Preferred Project Report

Bodangora Wind Farm

**PART 3A
Major Project MP 10_0157**

PREFERRED PROJECT REPORT

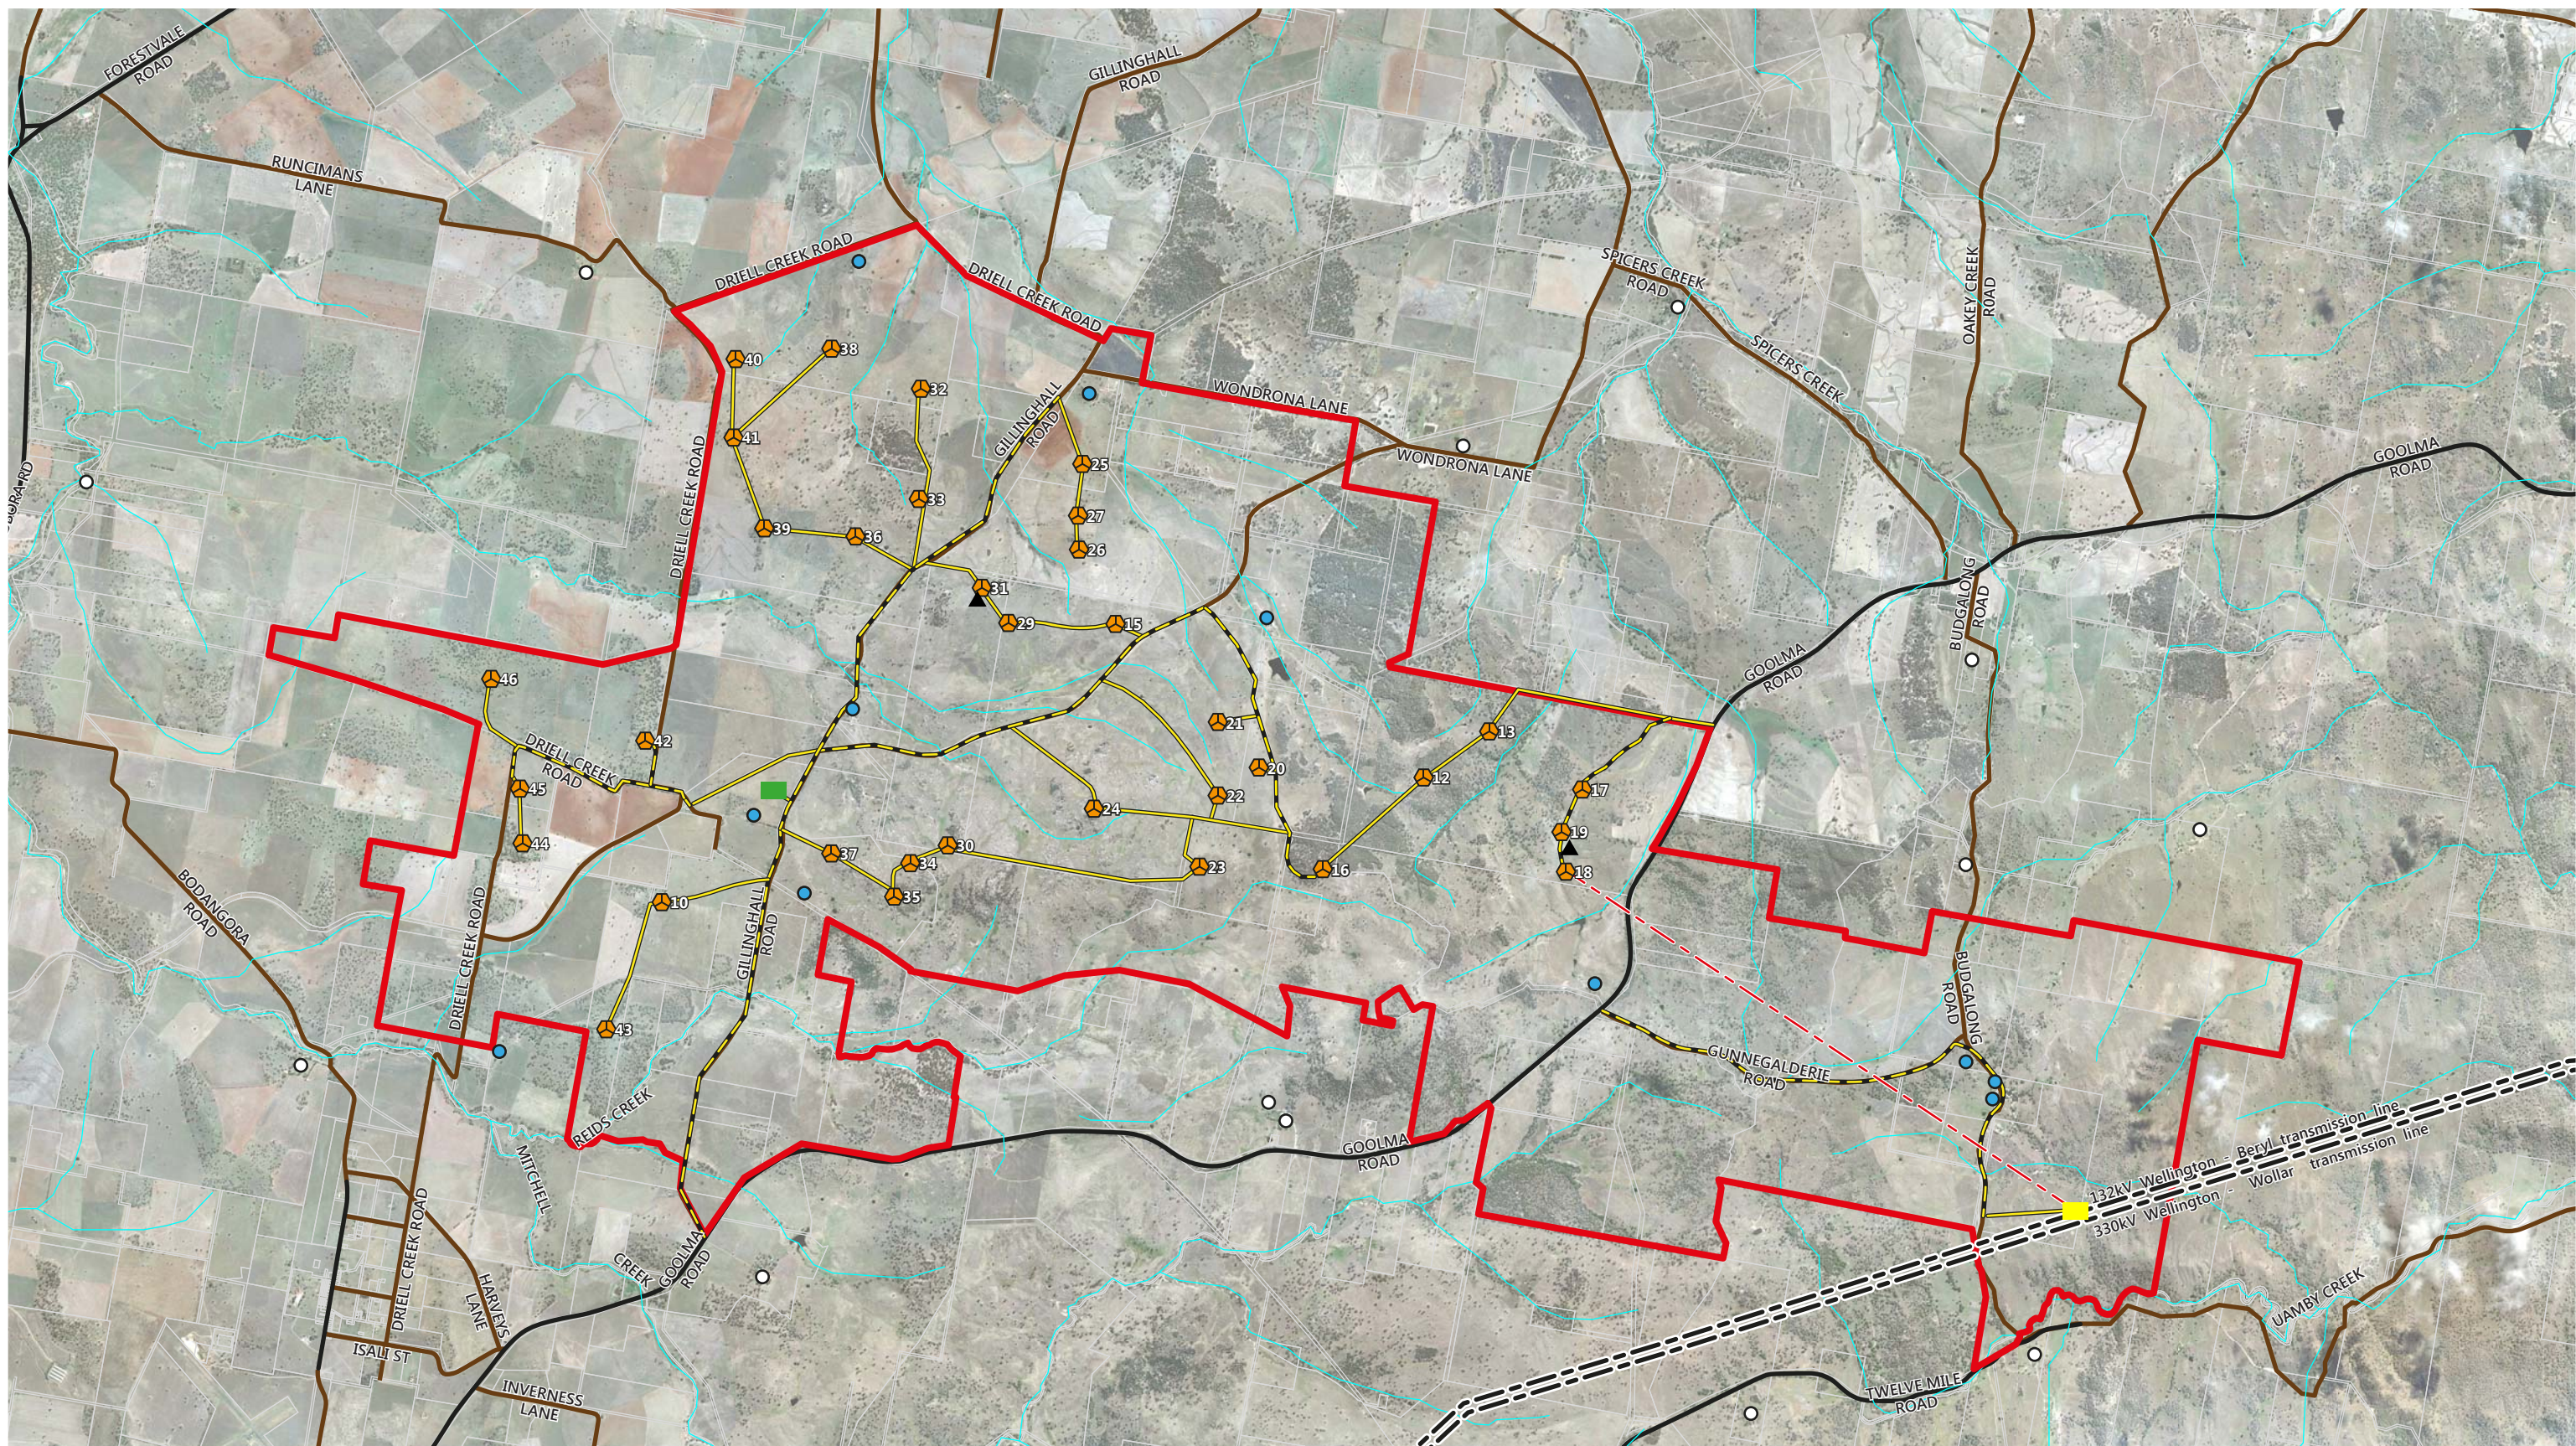
1. Access tracks and cabling between WTG 30 and WTG 34 have now been changed to 'optional'. The inclusion of these will depend on the decision of the new property owner, and whether or not they elect to be involved in the project. This change is in response to the submission received from the new owner and the discussions that have been held since being notified of the sale and does not affect the essential nature of the project should the land not be made available by the current land owner for the project.

2. The proposed power line connecting to WTG 18 and the substation has been clarified as either underground or overhead. This was previously identified in the EA as overhead. It is likely that the final easement will be a combination of both, and will depend on any environmental and geotechnical restrictions. The proponent will endeavour to use underground where practical in order to minimise any perceived visual impact of the power line, however overhead lines will be maintained between wind turbines as necessary including in sensitive locations such as creek crossings and areas of native vegetation. Labelling of Transgrid transmission lines has also been switched to reflect correct alignment.

- 33kV cabling to run adjacent tracks / roads
- Option to remove tracks and cables between WTG 30 & 34
